September 16, 2021

Re: Letter of Intent for Colorado Springs Utilities Northeast Gravel Staging Area

- LEGEND**
-  NEW ASPHALT
 -  TRACKING AREA
 -  UNDERGROUND ELECTRICAL
 -  UNDERGROUND LOW VOLT
 -  UNDERGROUND SPARE CONDUIT
- SYMBOLS**
-  ELECTRICAL PANEL
 -  HOFFMAN BOX
 -  GATE OPERATOR
 -  LIGHT POLE
 -  CARD READER PEDESTAL
 -  WALL PACKS

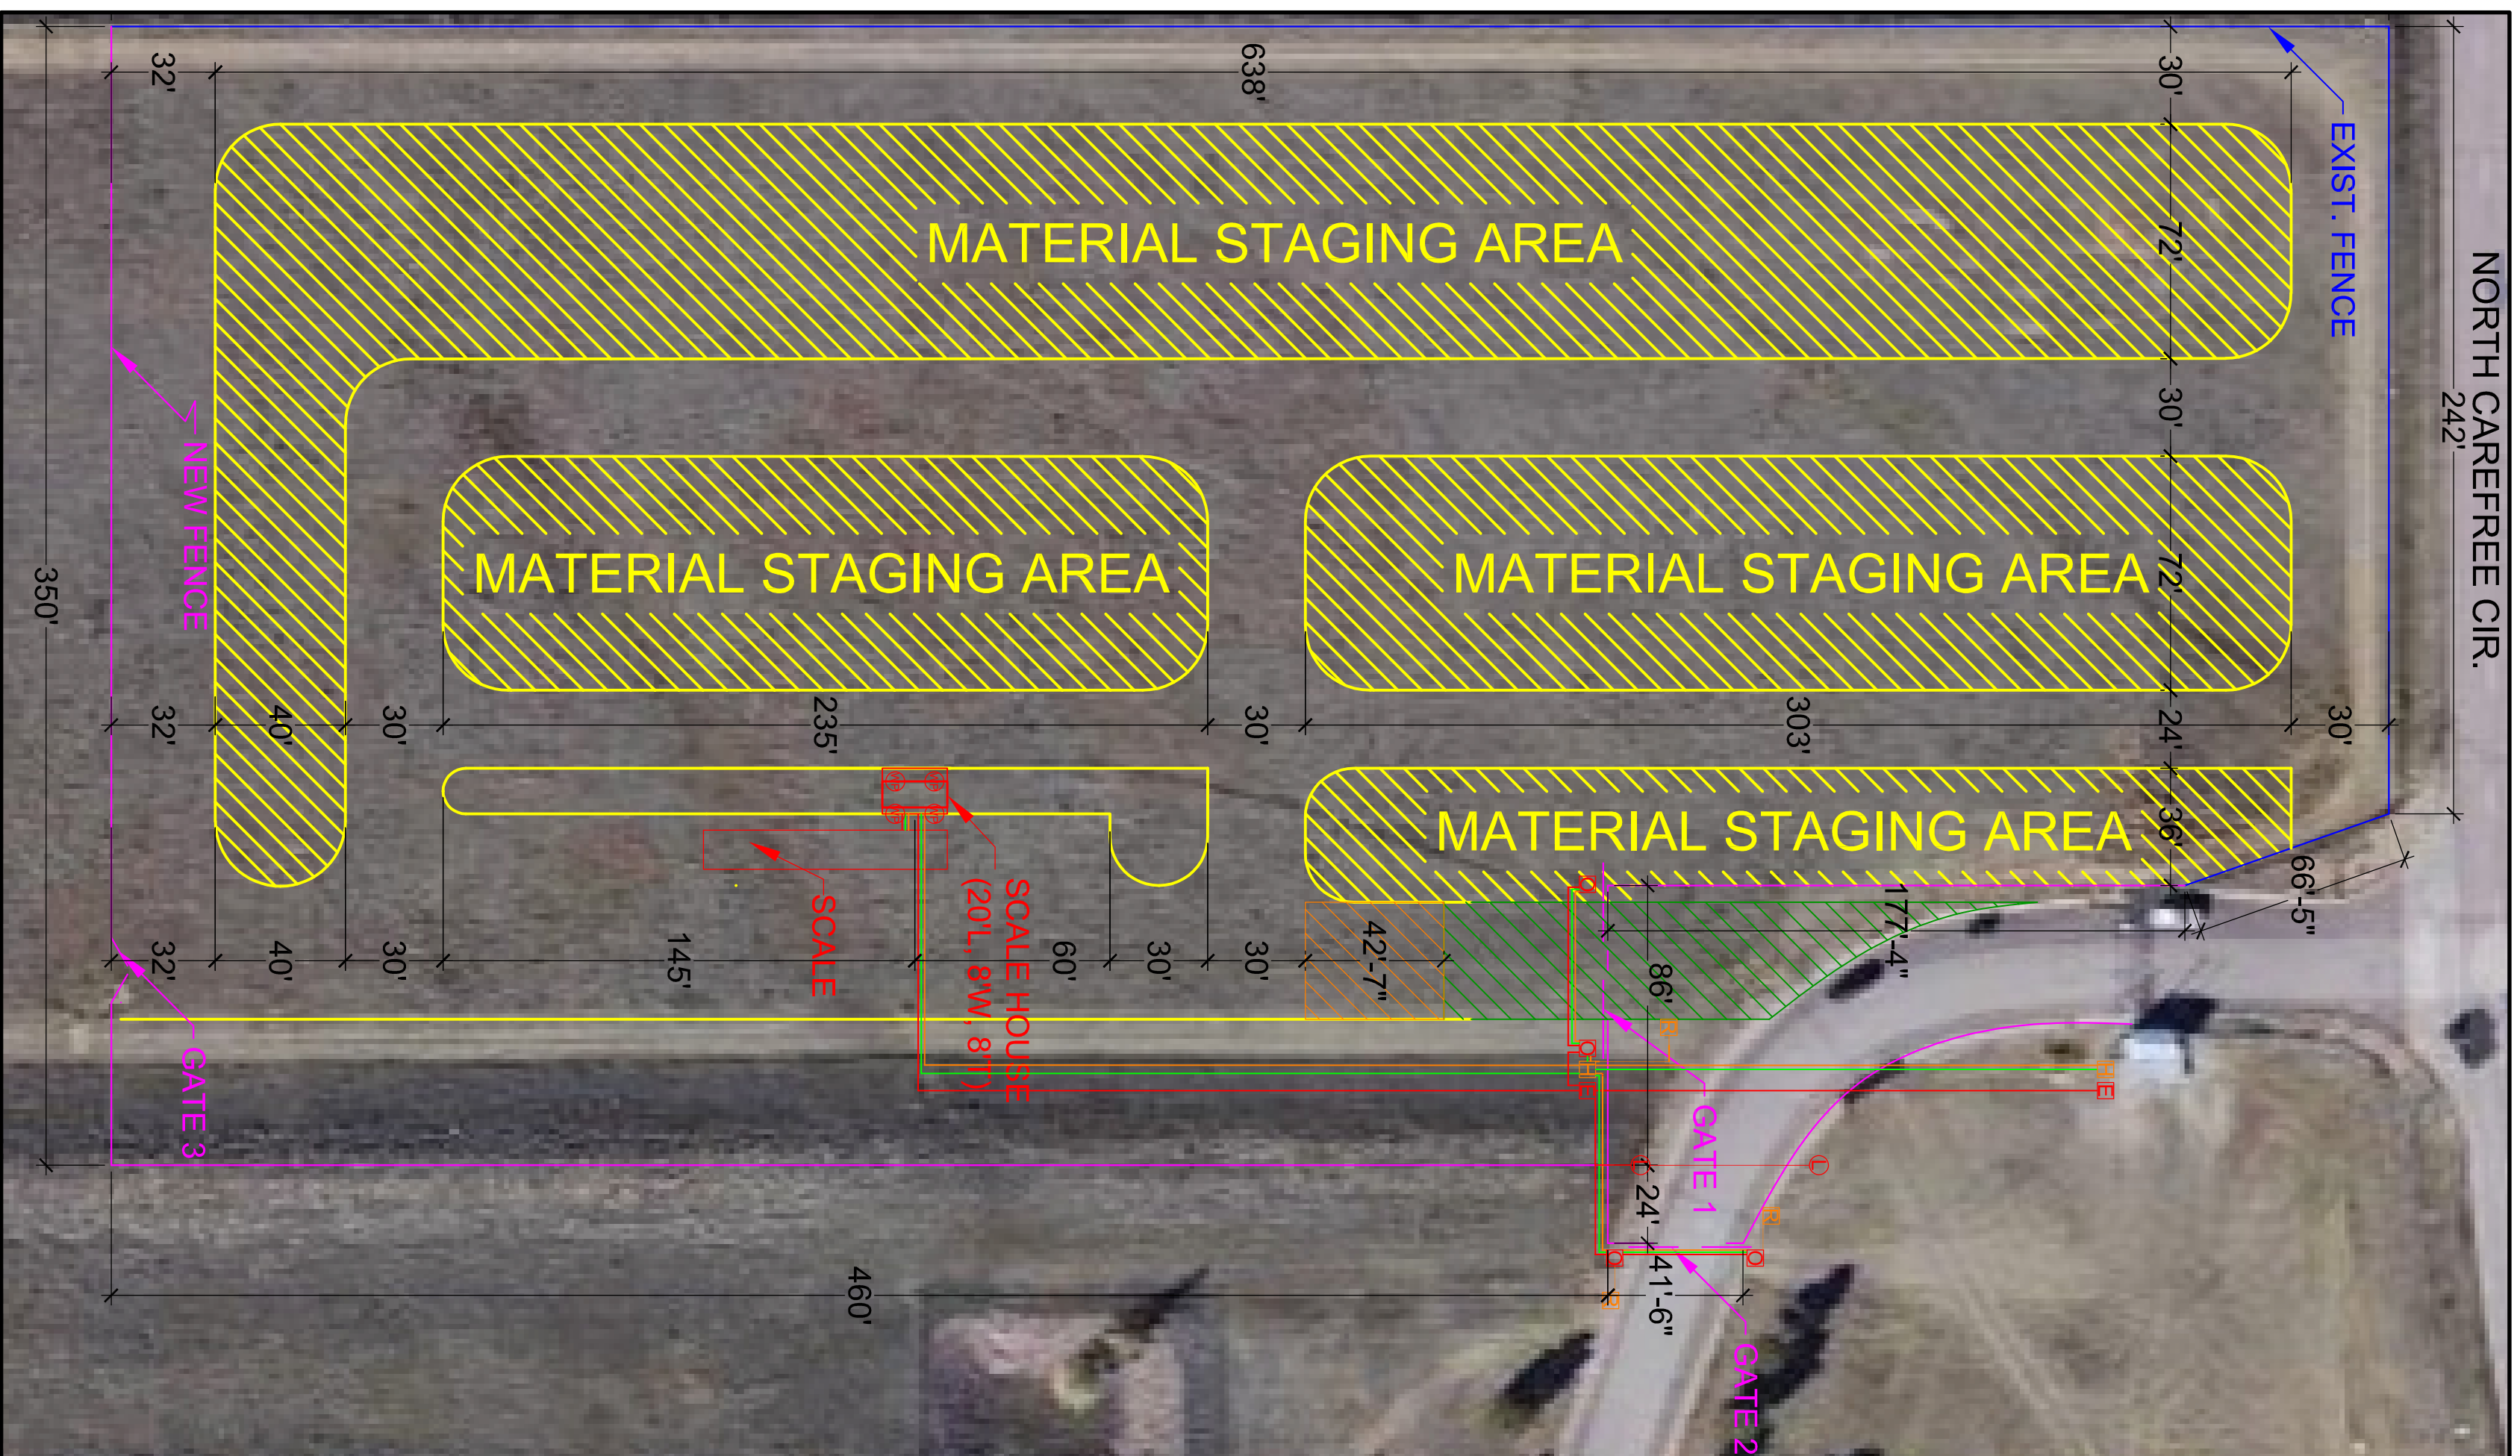
Please provide revisions according to comments on site plan and traffic report.

ATTACHMENT 5 – Lighting Plan

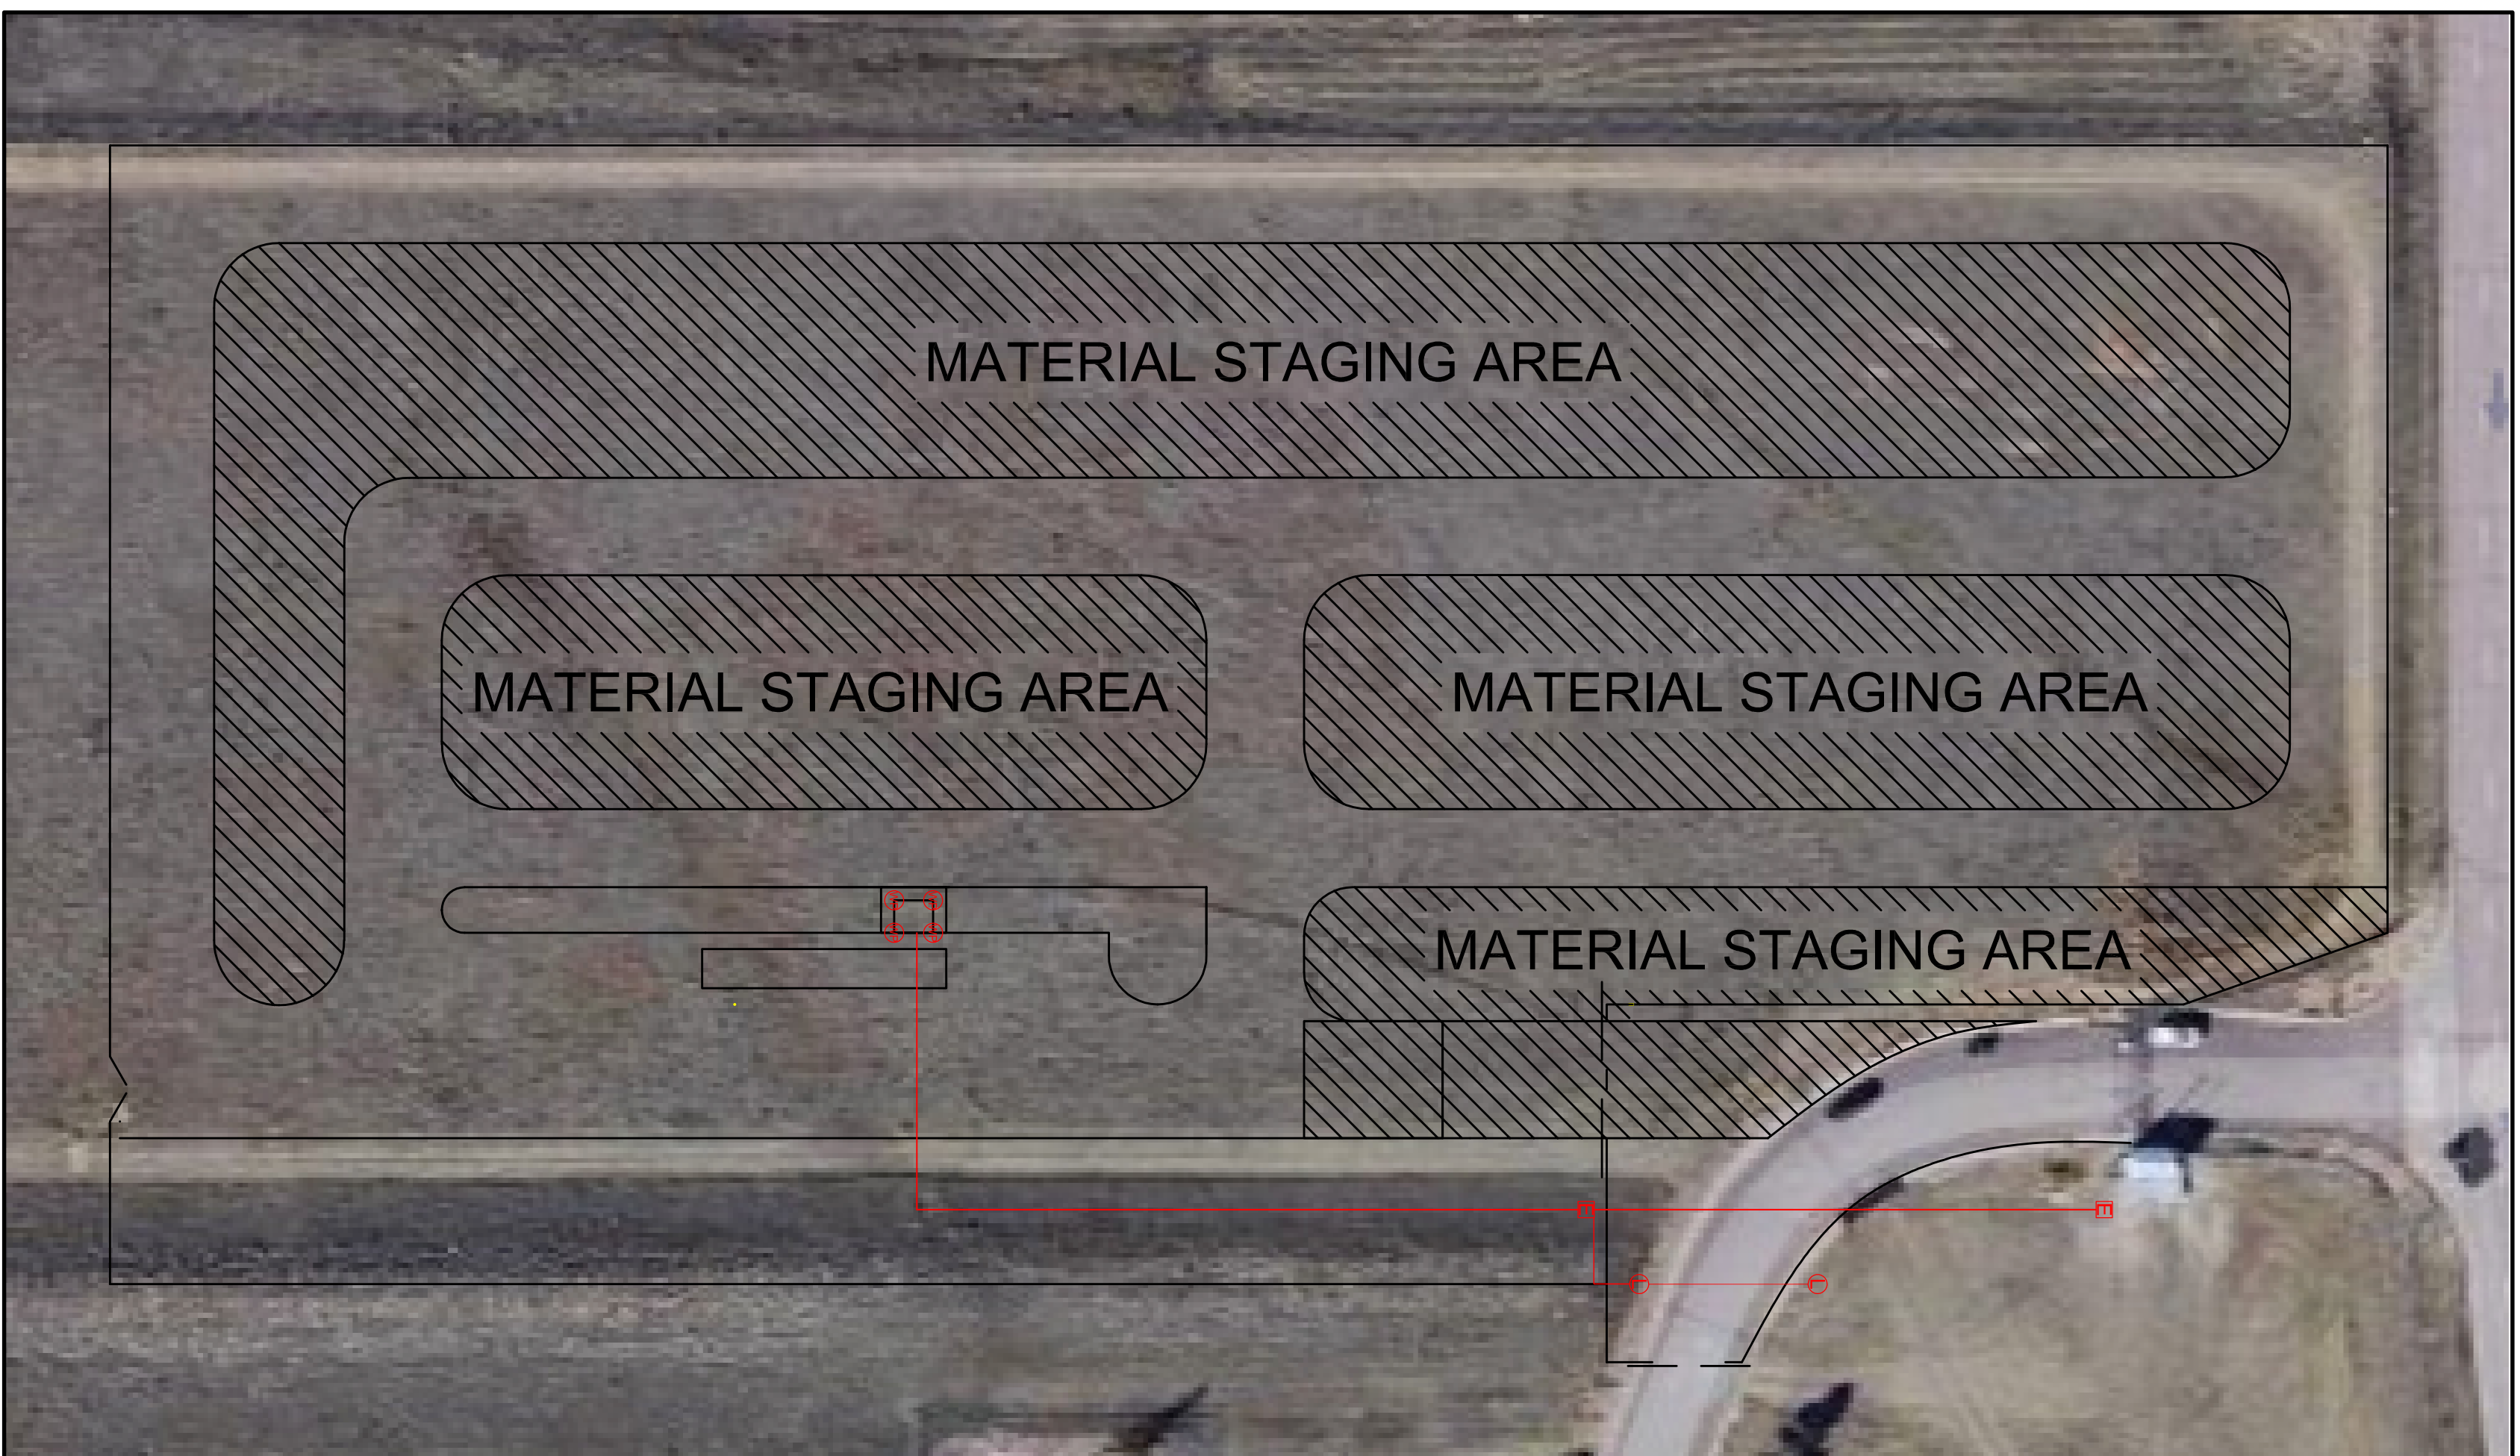
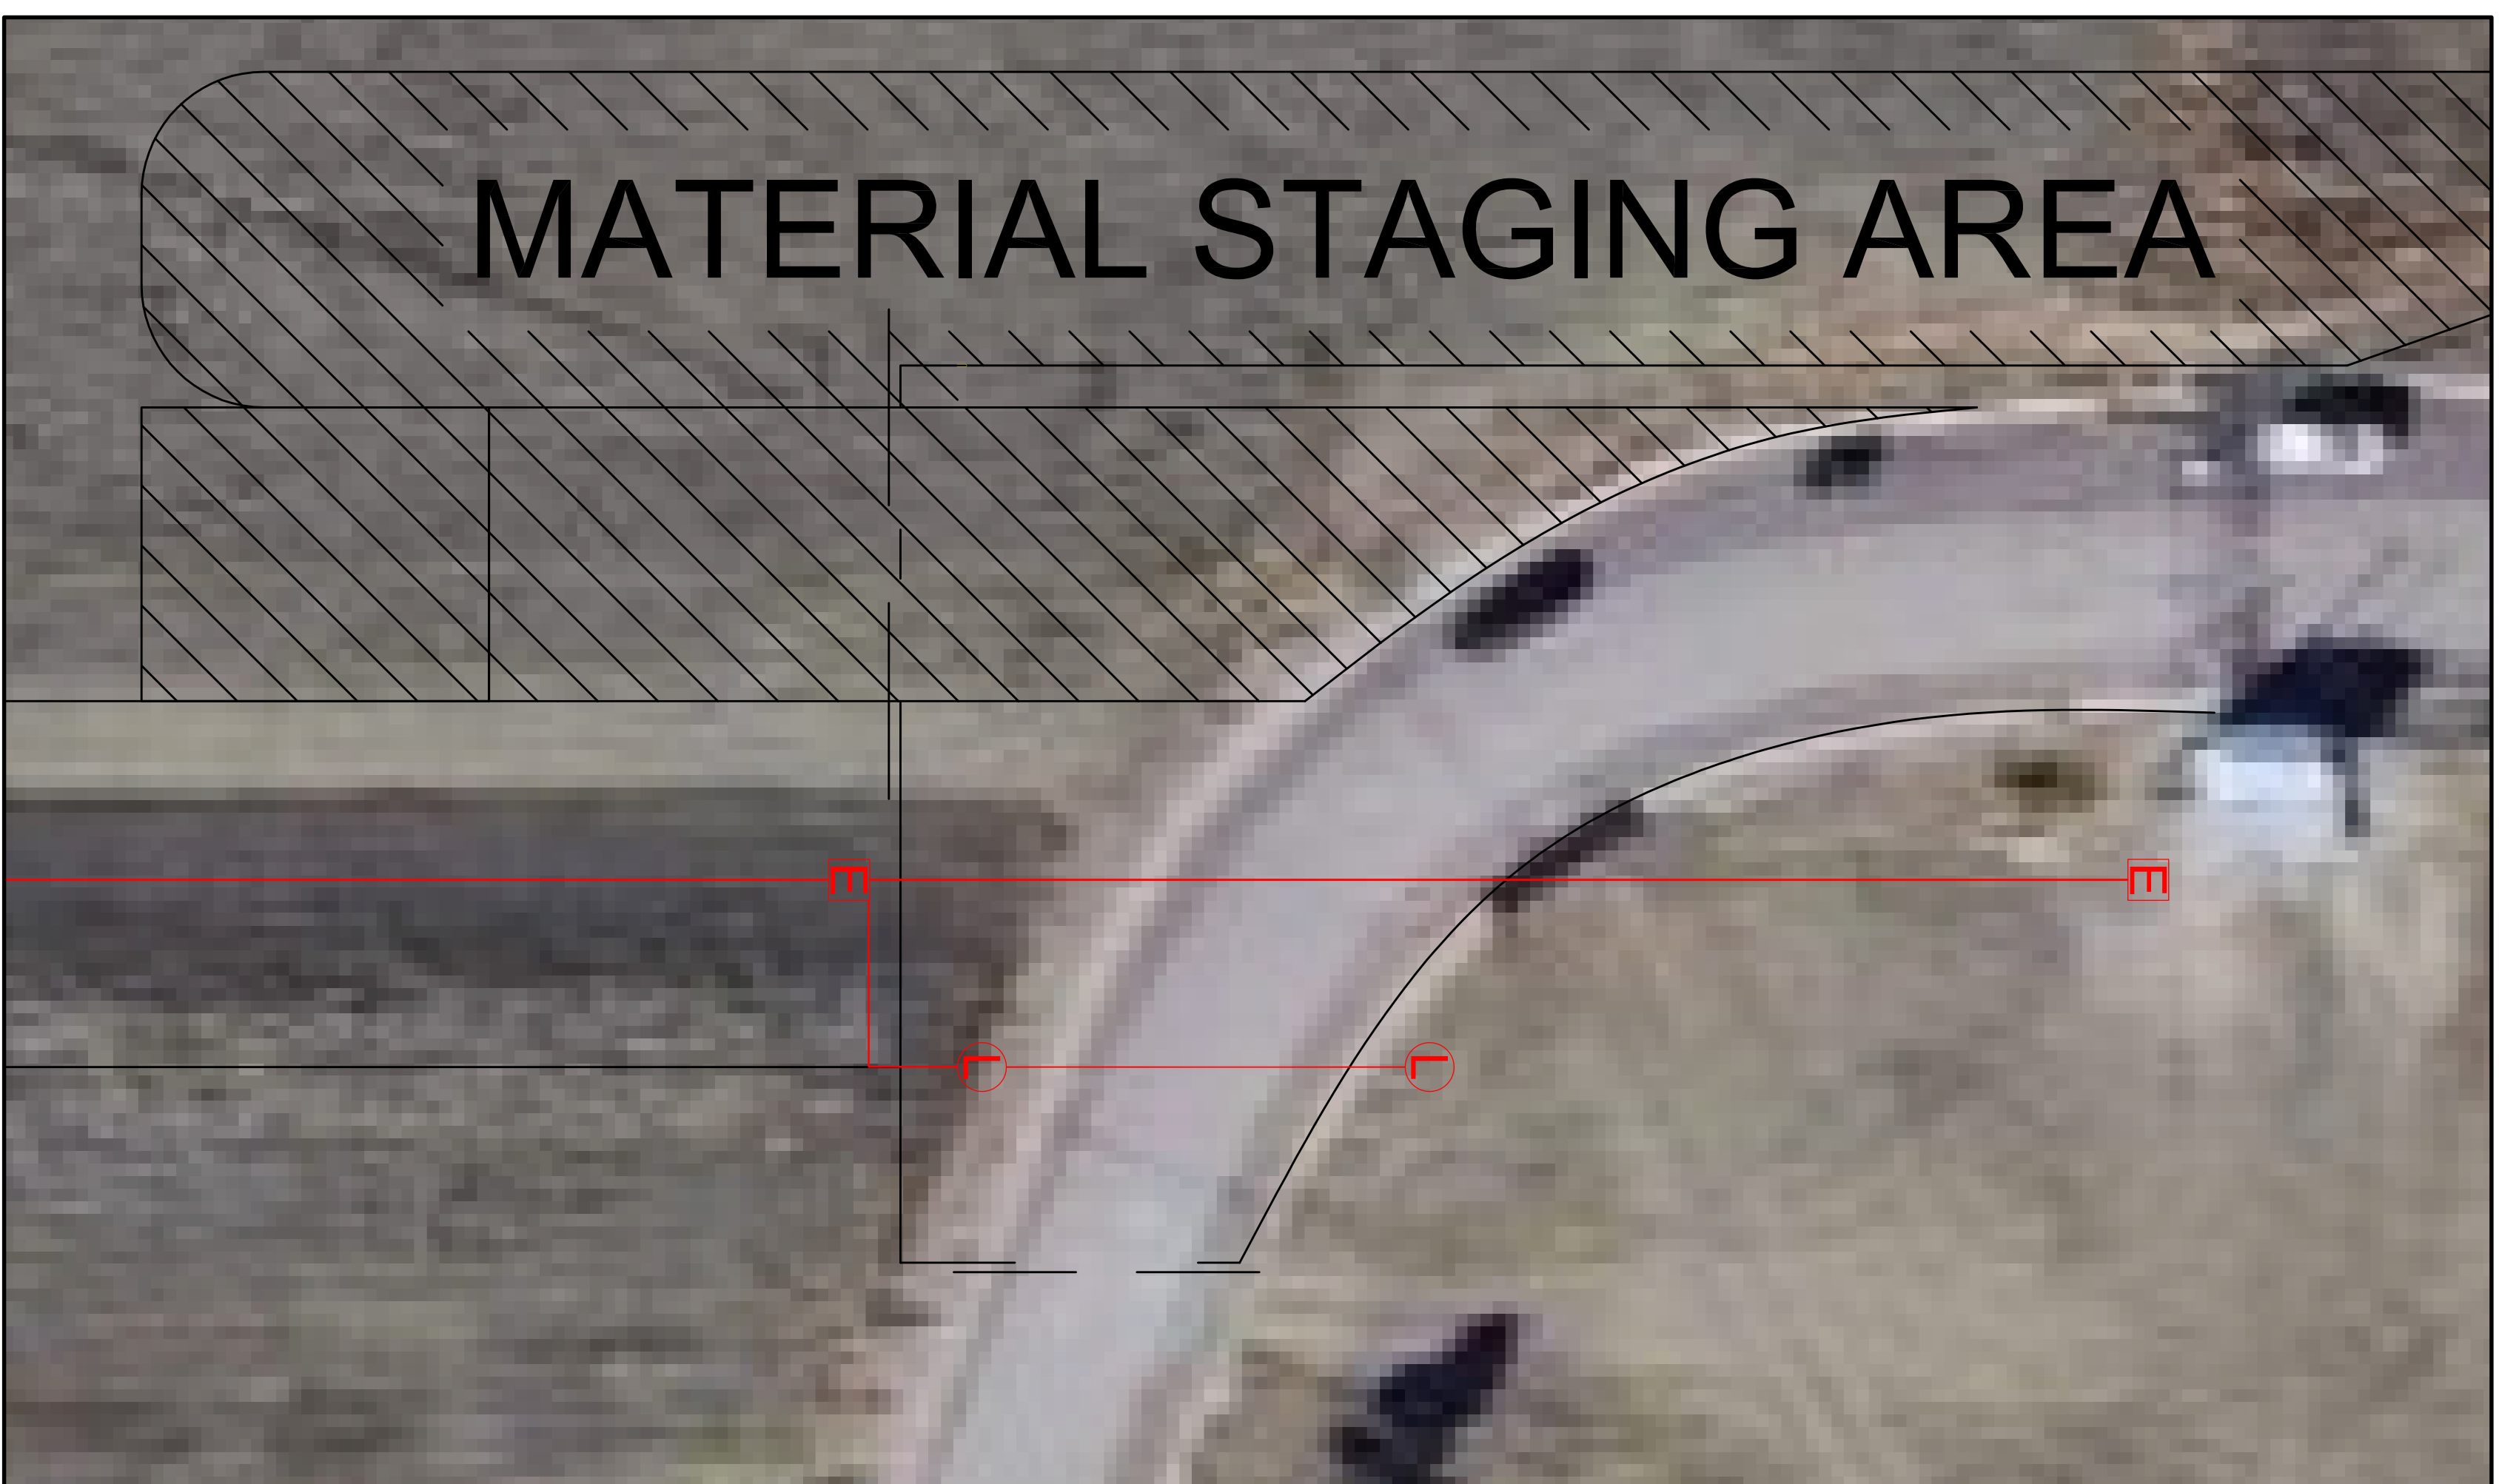
Note that lighting fixtures cannot exceed 15 ft per Sec. 6.2.3 of the Code. Since this application only covers the approval for the site location, and not the specific aspects of the site plan, you will need to make changes accordingly on the site development application. If you wish to include the documentation regarding landscaping, lighting, and parking on this application, you may - however, note that changes to the site development plan may delay approval of this application if that is the case to prevent conflicting information between applications.
